## EL PASO COUNTY GRADING AND EROSION CONTROL PLAN CHECKLIST

EPC Project Number: SF2315

SHEET NO.:
GEC-1

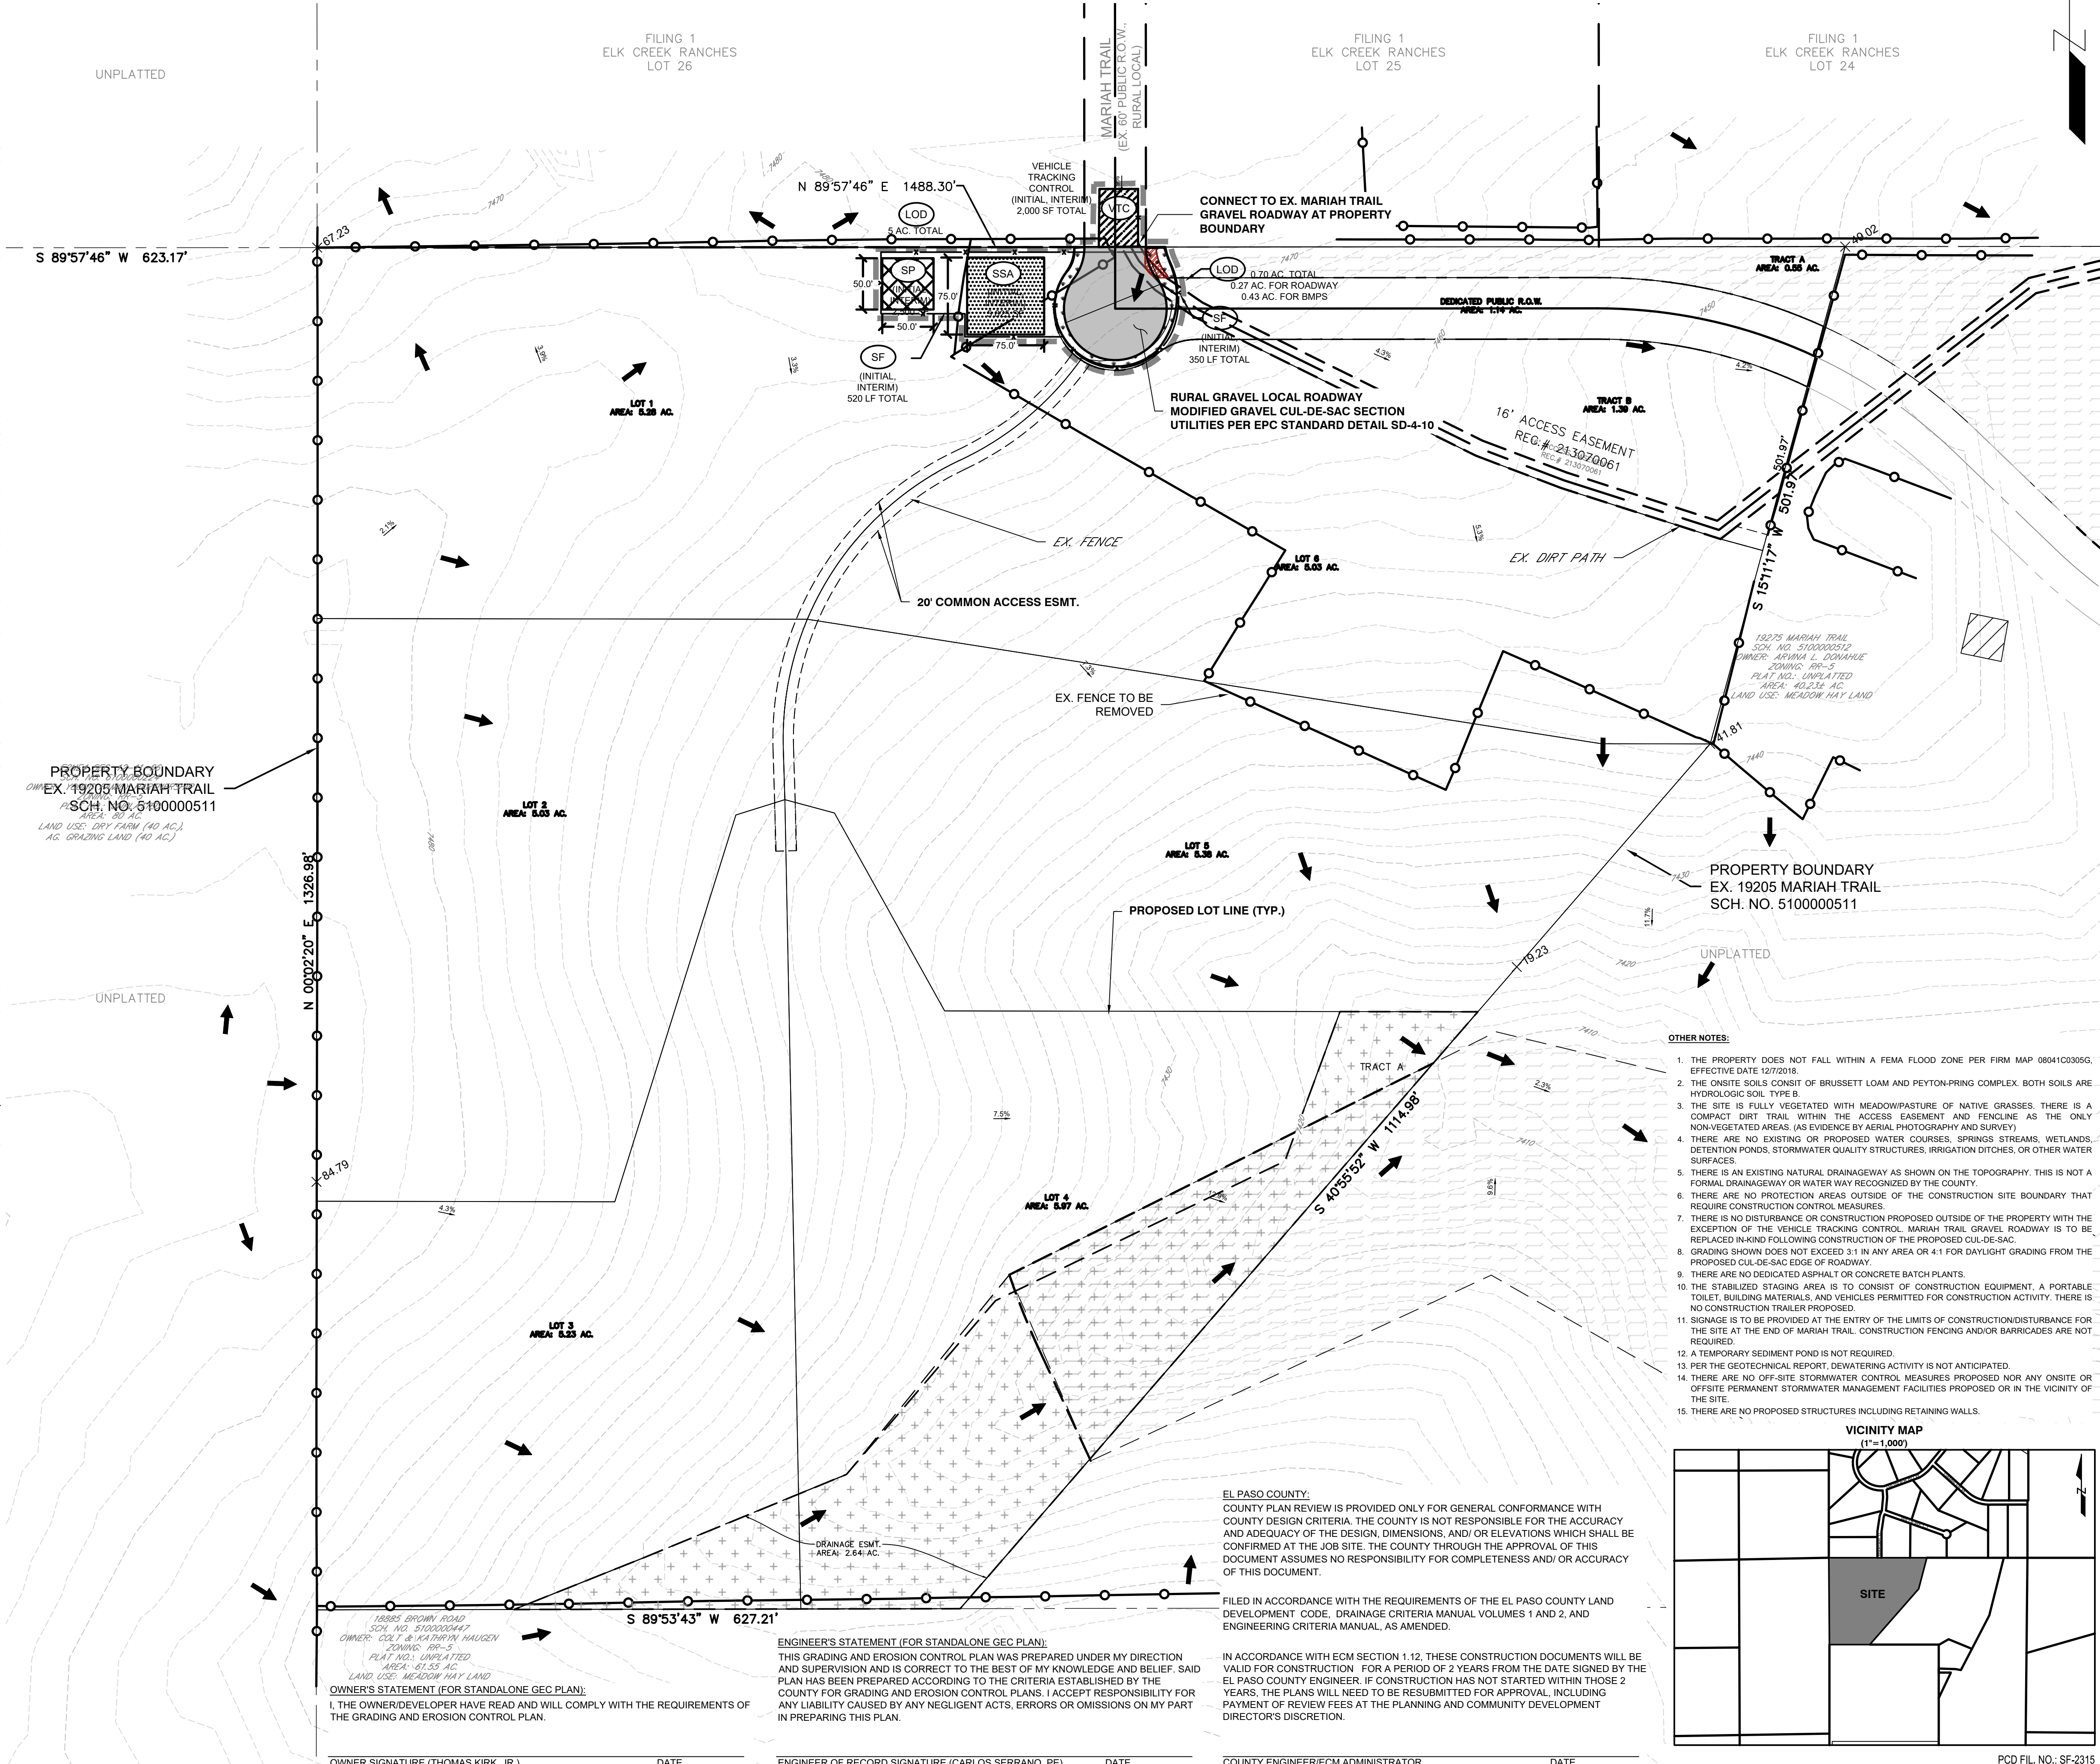
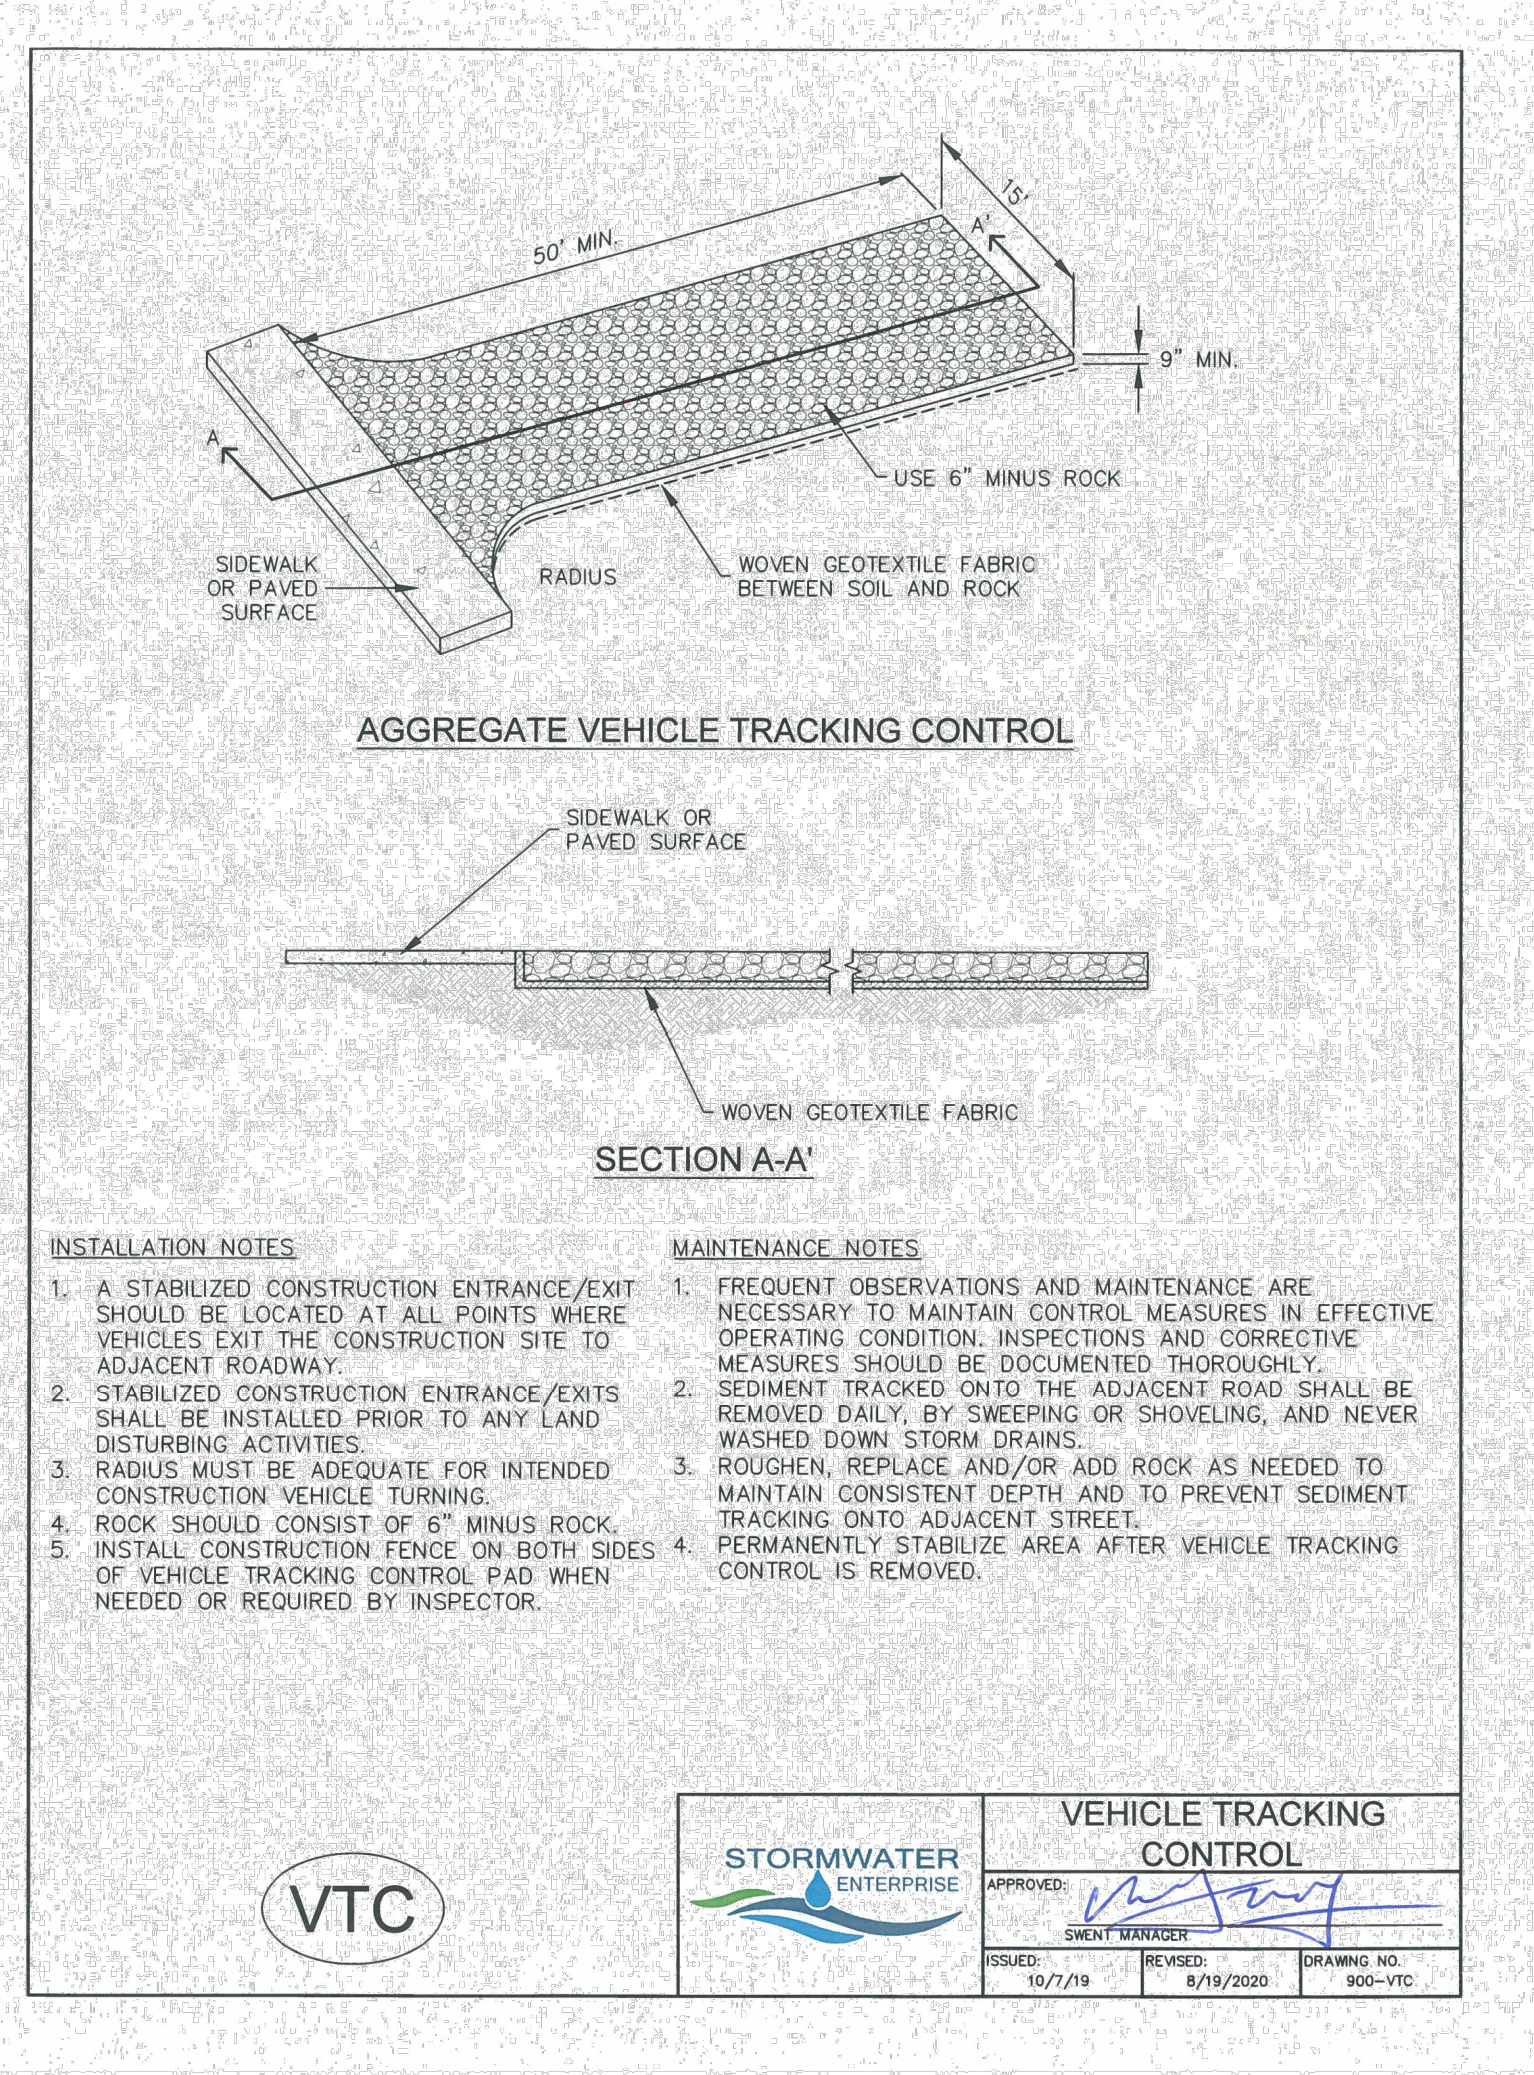
Applicant	EPC
<b>1. GRADING AND EROSION CONTROL PLAN</b> (complete form using Y, N, N/A in the "Applicant" column)			
a	Vicinity map		Y
b	Adjacent city/town/jurisdictional boundaries, subdivision names, and property parcel numbers labeled		Y
c	North arrow and acceptable scale (1"=20' to 1"=100')		Y
d	Legend for all symbols used in the plan		Y
e	Existing and proposed property lines. Proposed subdivision boundary for subdivision projects		Y
f	All existing structures		Y
g	All existing utilities		Y
h	Construction site boundaries		Y
i	Existing vegetation (notes are acceptable in cases where there is no notable vegetation, only grasses/weeds, or site has already been stripped)		Y
j	FEMA 100-yr floodplain		N/A
k	Existing and proposed water courses including springs, streams, wetlands, detention ponds, stormwater quality structures, roadside ditches, irrigation ditches and other water surfaces. Show maintenance of pre-existing vegetation within 50 feet of a receiving water <span style="border: 1px solid black; padding: 2px;">Show RPA areas.</span>

l	Existing and proposed contours 2 feet or less (except for hillside) <span style="border: 1px solid black; padding: 2px; color: red;">Unresolved - dothartford 08/24/2023 2:43:03 PM</span>		Y
m	Limits of disturbance delineating all anticipated areas of soil disturbance		Y
n	Identify and protect areas outside of the construction site boundary with existing fencing, construction fencing or other methods as appropriate		Y
o	Off-site grading clearly shown and called out		N/A
p	Areas of cut and fill identified		Y
q	Conclusions from soils/geotechnical report and geologic hazards report incorporated in grading design (slopes, embankments, materials, mitigation, etc.)		Y
r	Proposed slopes steeper than 3:1 with top and toe of slope delineated. Erosion control blanketing or other protective covering required		N/A
s	Stormwater flow direction arrows		Y
t	Location of any dedicated asphalt / concrete batch plants		N/A

u	Areas used for staging, storage of building materials, soils (stockpiles) or wastes. The use of construction office trailers requires PCD permitting		Y
v	All proposed temporary construction control measures, structural and non-structural. Temporary construction control measures shall be identified by phase of implementation to include "initial," "interim," and "final" or shown on separate phased maps identifying each phase		Y
w	Vehicle tracking provided at all construction entrances/exits. Construction fencing, barricades, and/or signage provided at access points not to be used for construction		Y
x	Temporary sediment ponds provided for disturbed drainage areas greater than 1 acre		N
